**Consultation Response from KC,
Highways Development Management**

2024/93250 Agrosmart Ltd, Red Doles Lane, Leeds Road, Huddersfield, HD2 1YF

Erection of warehouse extension for storage of product containers/pallets

Date Responded: 21-1-2025.

title general arrangement as proposed
number 24060D-03-P03
scale 1:100
size A1

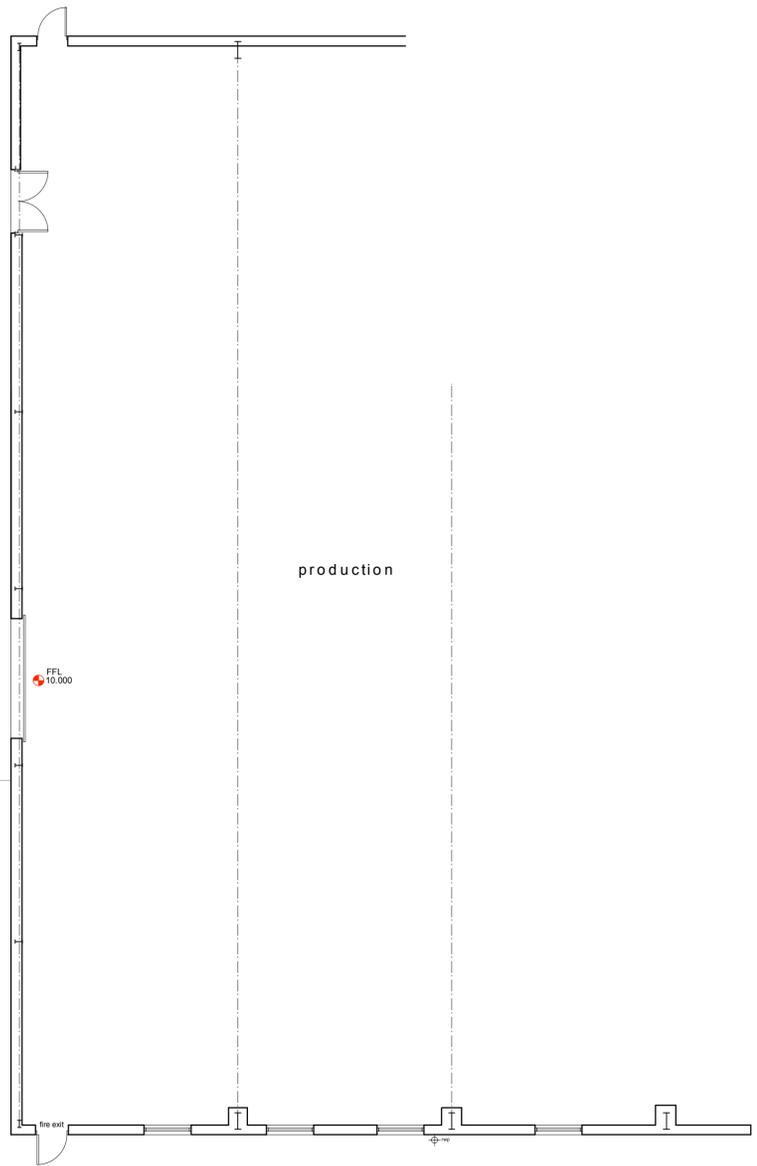
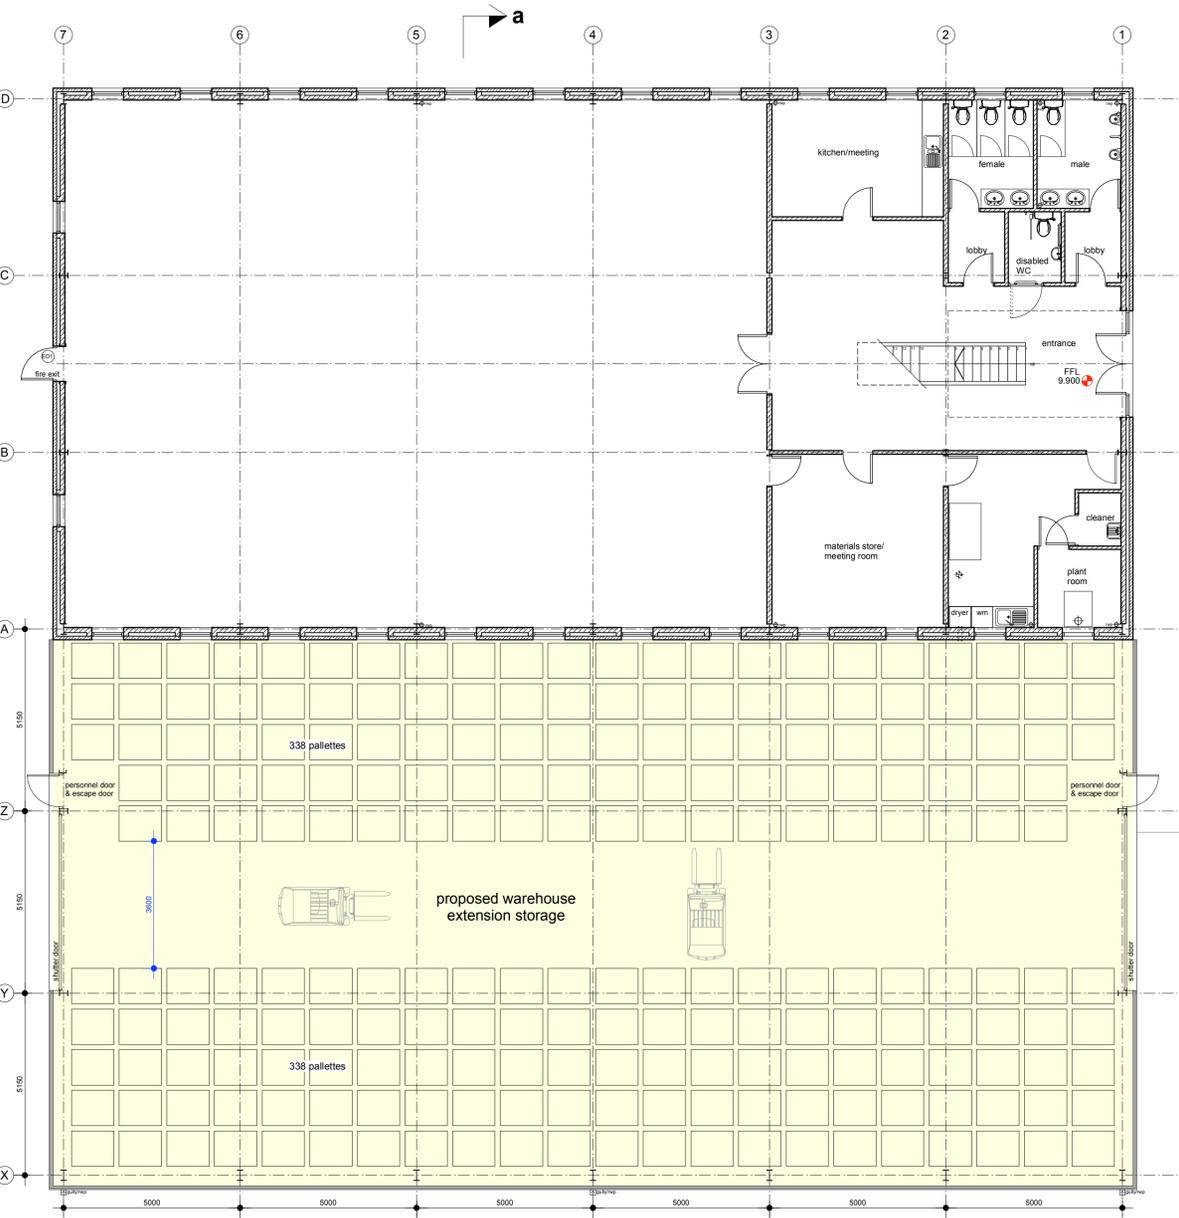
Highways development Management only concerns with these proposals is the loss of existing off-street parking.

Can the applicants be asked to provide a detailed justification for the loss of the existing off-street parking and the number proposed.
